Application number: 2025/91370	
What is the application for?:	REVISED AND ADDITIONAL INFORMATION RECEIVED: Demolition of existing dwelling and
Address of the site or building:	Land at, Gynn Lane, Honley, Holmfirth, HD9 6LF
Postcode:

## COAL WORKINGS AT THE TOP OF THE SITE

SECTION E-E

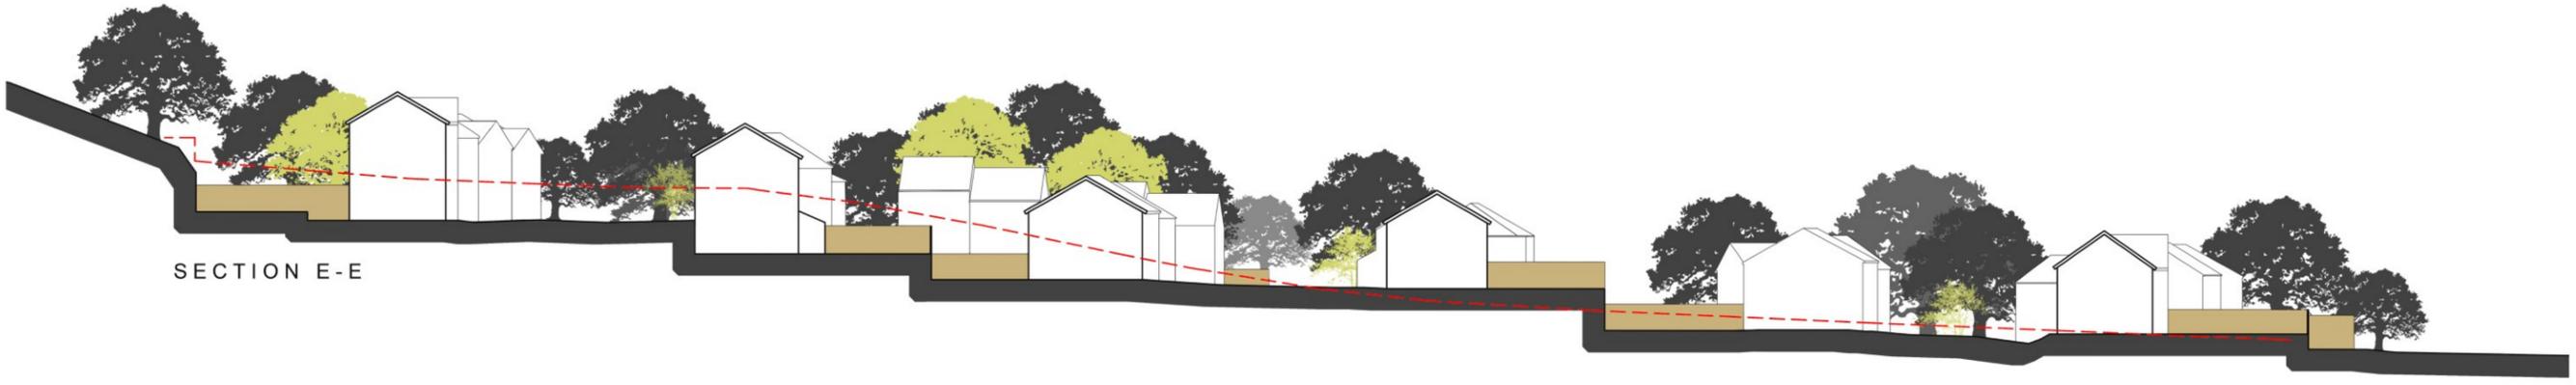
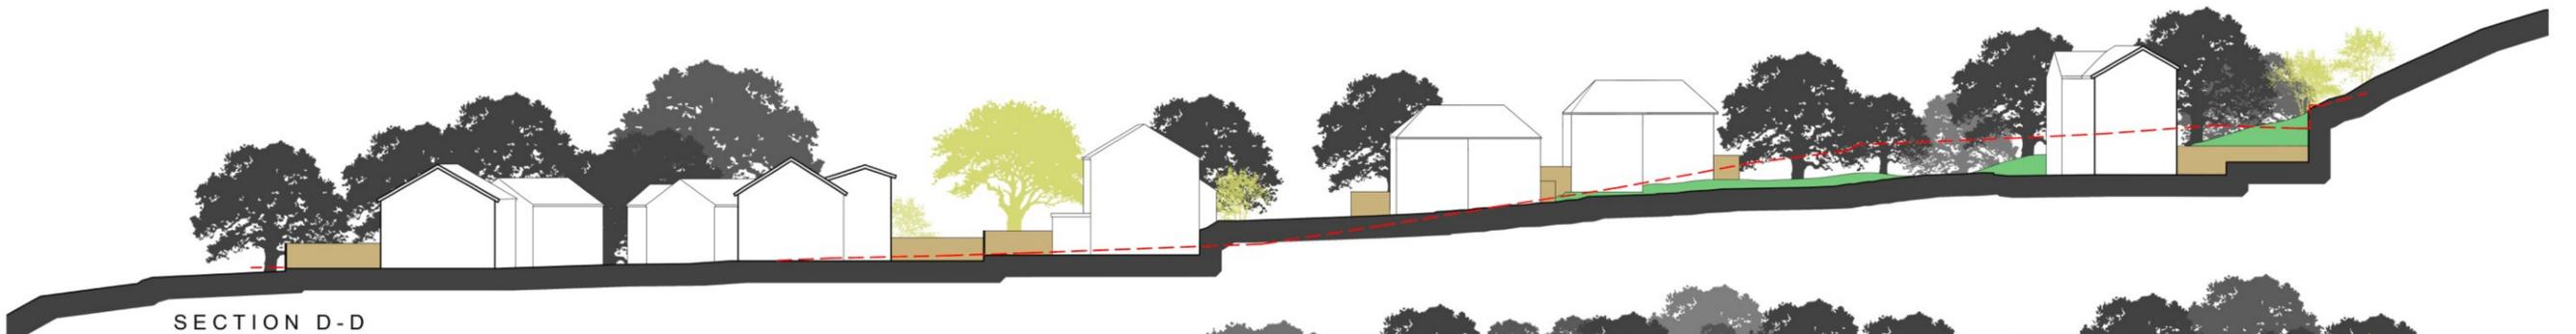
The site between the area to be grouted and the railway embankment will have 5m removed to allow the 6 houses by the railway embankment and the 3 opposite to be built, using plans 1127054 site sections section EE. The first and second on the left are 3 story houses. The red line is the ground level which runs through the houses halfway up on the first floor, about 5m up from the ground floor level. When this ground is removed it will not have the required thickness of competent rock and will also require grouting.

The fact that so much was to be removed may not have been available or later made available to Lithos when they wrote the report that this part of the site did not require grouting as it had competent rock cover.

Using the precautionary principal this will now need grouting and reinforced foundations for the 2 retaining walls supporting the railway embankment at the back of the 6 houses as they will not now be required depth of competent rock.
